**Marine
Management
Organisation**

MMO Reference: DCO/2022/00007
Planning Inspectorate Reference: EN010125
Identification Number: 20050160

Planning Act 2008, RWE Renewables UK Dogger Bank South (West) Ltd and RWE Renewables UK Dogger Bank South (East) Ltd Proposed Dogger Bank South Offshore Wind Farms Order

Deadline 2 Summary

Figure: 2-2	Drawing No: PB2340-MAR-OF-ZZ-DR-Z-0013	
Co-ordinate system: WGS 1984 UTM Zone 31N	Page Size: A3	Scale: 1:950,000
Project: Dogger Bank South Offshore Wind Farms	Report: Heat Mapping Report: Atlantic Herring and Sandeel

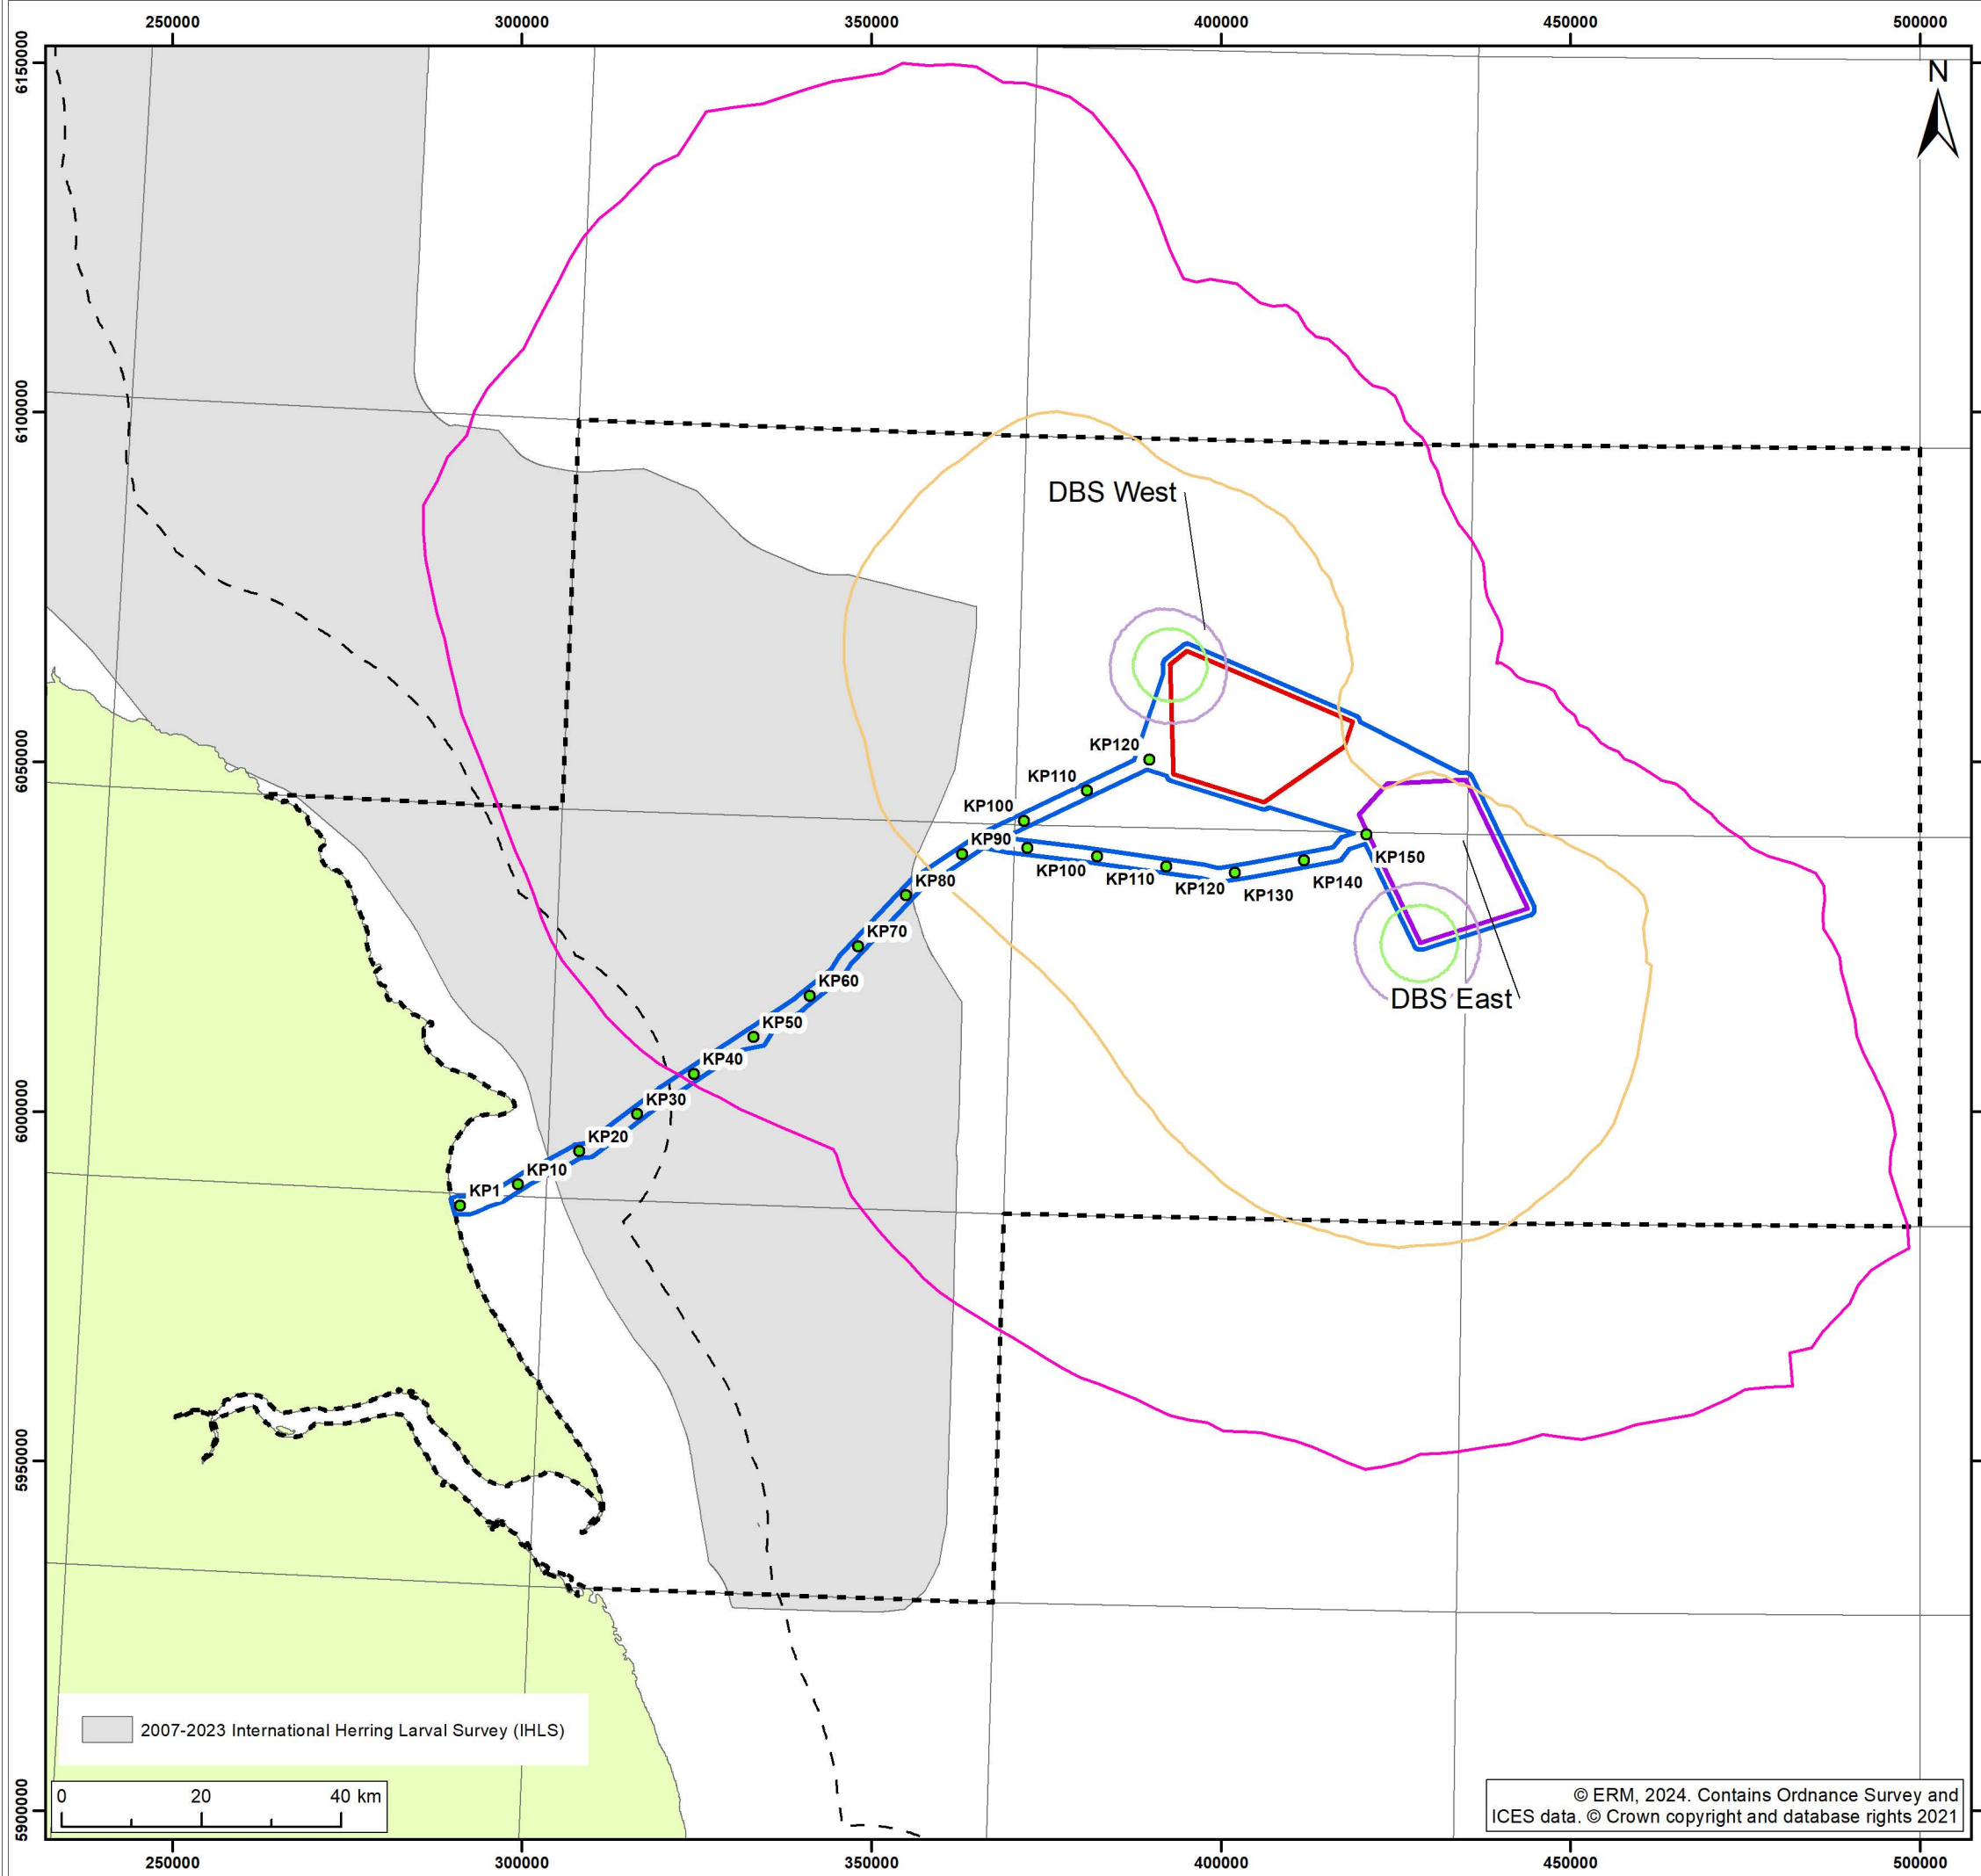
2.2.2 Further information has been provided however there are still comments. The vessel monitoring data (VMS) layer should either be corrected to present 10 years of VMS data, or the Applicant should be able to demonstrate why the spatial data provided in the 2020 VMS data is more expansive than the sum of 10 years of VMS activity.
